ADDRESS : 324 GILCHRIST RD SUBDIV:
 CONTRACTOR : TCC VANDERBUILT LLC PHONE : (919) 774-6319
 OWNER : BROWN BOBBY & JOSEPHINE PHONE :
 PARCEL : 09-9575- - -0181- -07-
 APPL NUMBER: 17-50042224 CP MODULAR HOME
 DIRECTIONS : T/S: 09/08/2017 09:52 AM LLUCAS ----
 27 TO NC 24 TO GILCHRIST RD - TURN
 RIGHT GO ABOUT 1.5 MILES ON RIGHT

STRUCTURE: 000 000 41X72 4BDR 2BTH W/GAR W/DECK W/SUNROM
 FLOOD ZONE : FLOOD ZONE X
 # BEDROOMS : 4.00 PROPOSED USE : SFD
 SEPTIC - EXISTING? : COUNTY WATER SUPPLY : NEW SEPTIC

PERMIT: CPMH 00 CP MODULAR

Job 91192	Truss CCB37711	Truss Type CAPE COD	Qty 1	Ply 1	Commodore 315 NC R41P9F (WITH BEARING AT OH 1 SIDE) Ref. #3157426
---------------------	--------------------------	-------------------------------	-----------------	-----------------	---

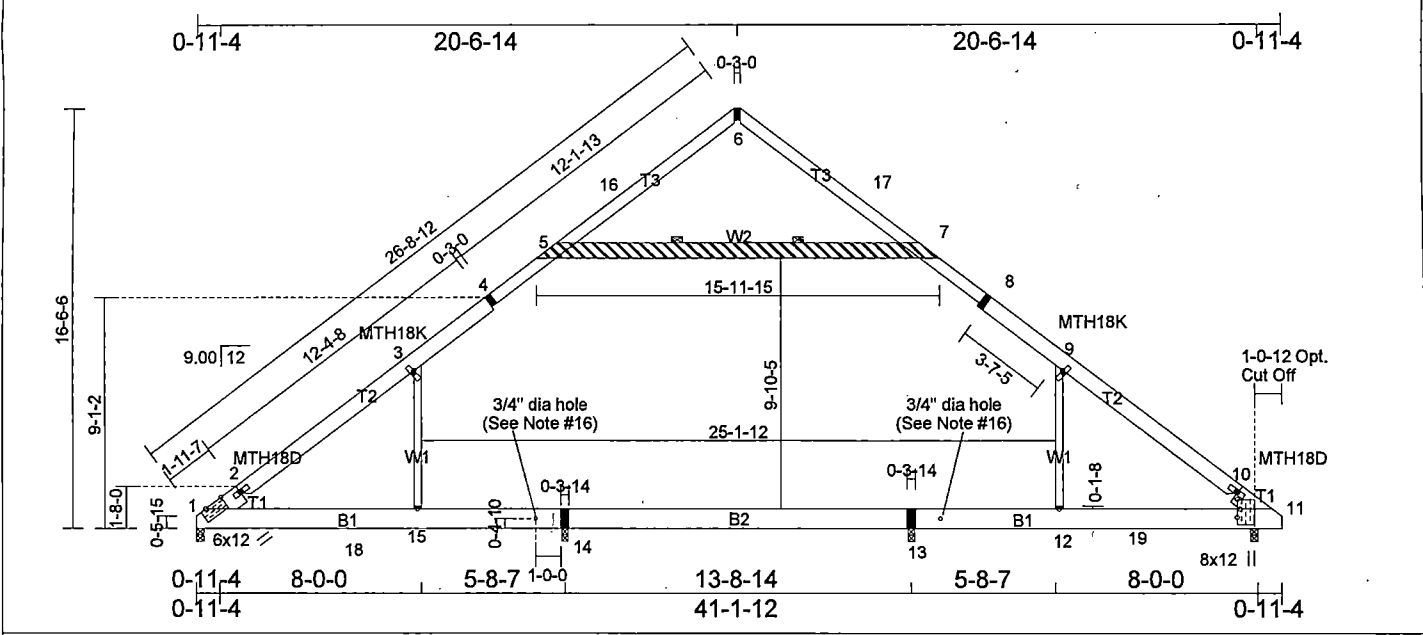
H824 01	2/28/18 2/28/18	OT AP	ENVIR. OPERATIONS PERMIT TIME: 17:00 VRU #: 003096245 T/S: 03/01/2018 10:11 AM KHINSON ----- T/S: 03/01/2018 10:11 AM KHINSON -----
B119 02	3/01/18 3/01/18	TSG DA	R*MOD MARRIAGE WALL TIME: 17:00 VRU #: 003095445 T/S: 02/28/2018 09:21 AM LLUCAS ----- WOULD LIKE THE MORNING 1- HAVE ENG ADDRESS FIELD CONNECTIONS OF TRUSS BOTTOM CORD PER DRAWING. LEAVE THESE AREAS OPEN ALL OTHER WORK IS OK TO CONTINUE.
M305 01	4/04/18 4/04/18	TSG AP	R*PLUMB SEWER CONNECTION TIME: 17:00 VRU #: 003110368 T/S: 04/03/2018 03:04 PM BPETRICH ----- T/S: 04/04/2018 03:45 PM DJOHNSON -----
P307 01	4/04/18 4/04/18	TSG AP	R*PLUMB WATER CONNECTION TIME: 17:00 VRU #: 003110376 T/S: 04/03/2018 03:04 PM BPETRICH ----- T/S: 04/04/2018 03:45 PM DJOHNSON -----
R425 01	4/10/18 4/10/18	TSG DA	FOUR TRADE ROUGH IN VRU #: 003112141 Key is hanging inside garage door to the right Please inspect Garage and deck framing too 1- strap garage door lvl 2-upstairs decking installed could

TYP/SQ	REQUESTED COMPLETED	INSP RESULT	DESCRIPTION RESULTS/COMMENTS
B119 03	5/10/18 5/10/18	TSG DP	not see area of concern during marriage wall inspection the connection of ttruss per engineer R*MOD MARRIAGE WALL VRU #: 003125473 Key in permit box or door unlocked! area still not open for inspetion as requested on 4/10/18 for roof truss repair per engineer letter \$50.00 re-inspection fee
B119 04	5/16/18	TIA	R*MOD MARRIAGE WALL TIME: 17:00 VRU #: 003127214 T/S: 05/14/2018 08:59 AM BPETRICH PLEASE CALL JULIAN WITH VANDERBUILT AT 919.200.9520 TO DISCUSS THE TRUSS LETTER - HE IS SAYING NO REPAIRS WERE NEEDED. THANKS! ENG ATTACHED TO TICKET (SEE BETH)
R425 03	5/16/18	TIA	FOUR TRADE ROUGH IN TIME: 17:00 VRU #: 003127222 T/S: 05/14/2018 09:01 AM BPETRICH

This letter is to confirm that Truss CCB37709 from the permit package is to be replaced with truss # CCB3711.
